KITTITAS COUNTY

MEMORANDUM

TO: All Staff
FROM: Public Works Plan Review Team
DATE: March 4, 2025
SUBJECT: BL-25-00004 Brown Rd Estates LLC

BL-25-00004 Brown Rd Estates LLC Critical Areas

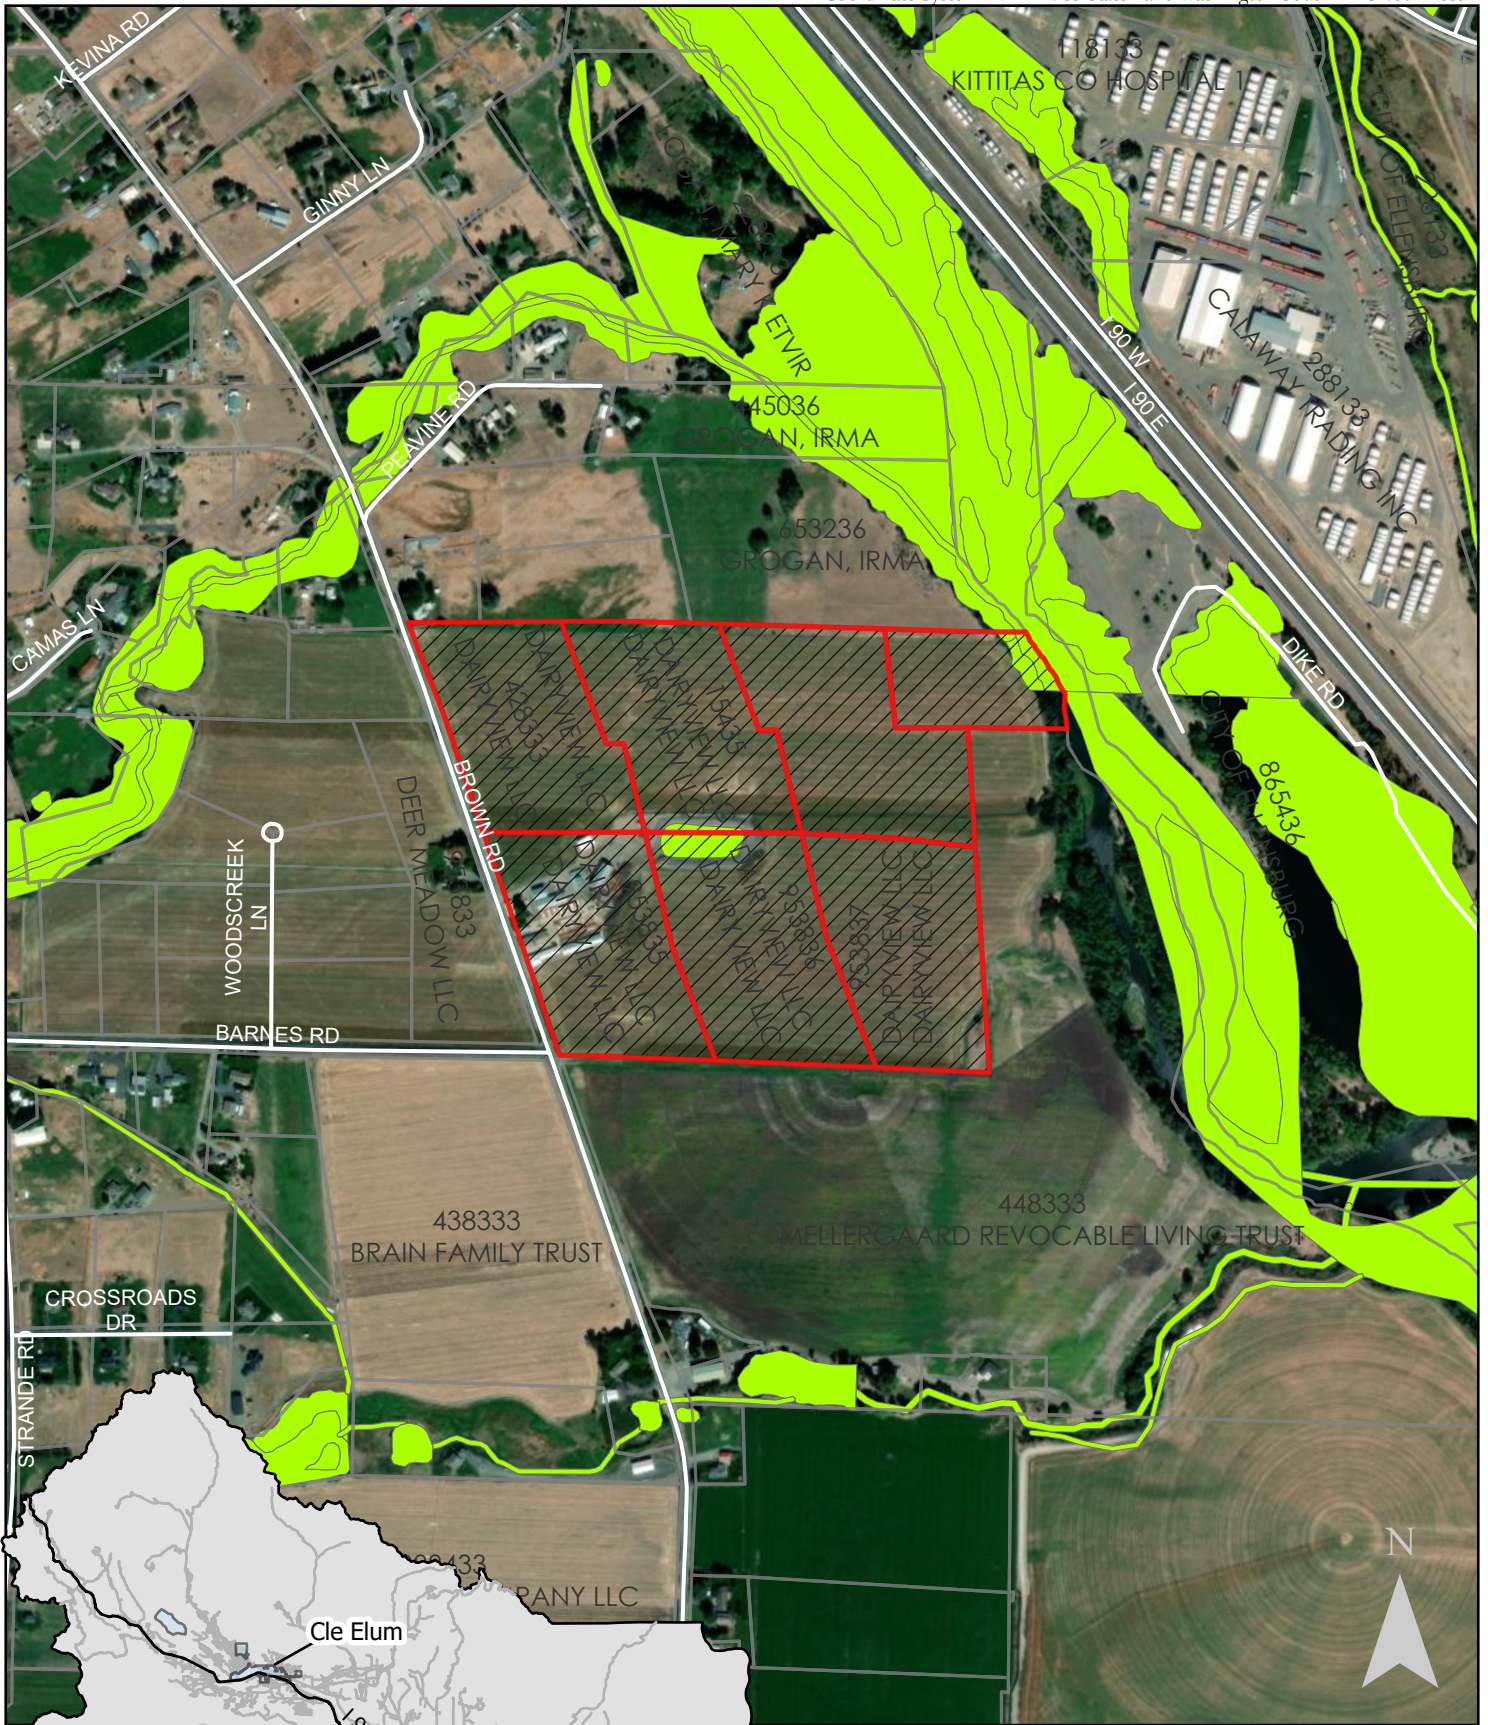
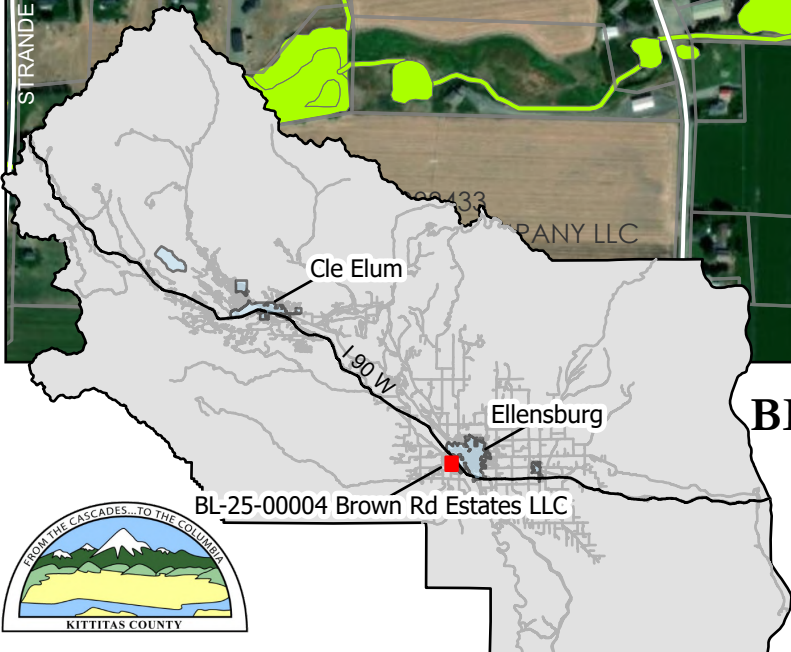
FLOOD	<p>A portion of parcel #618133 is within the FEMA identified special flood hazard area (100-year floodplain and floodway). Please be advised that the floodway is highly restricted and any development within the floodway must be permitted through a floodplain development permit and must demonstrate no rise of 100-year flood elevations before being permitted. No new or substantially improved residences are allowed within the floodway.</p> <p>If possible, any future development should remain outside of the floodplain in order to reduce risk and avoid mandatory flood insurance purchase requirements. All activities within the floodplain must be permitted through the floodplain development permit process and follow the regulations within KCC 14.08. (SC)</p>
WATER MITIGATION/ METERING	No comments. (SC)
AIRPORT	No comments. (JS)
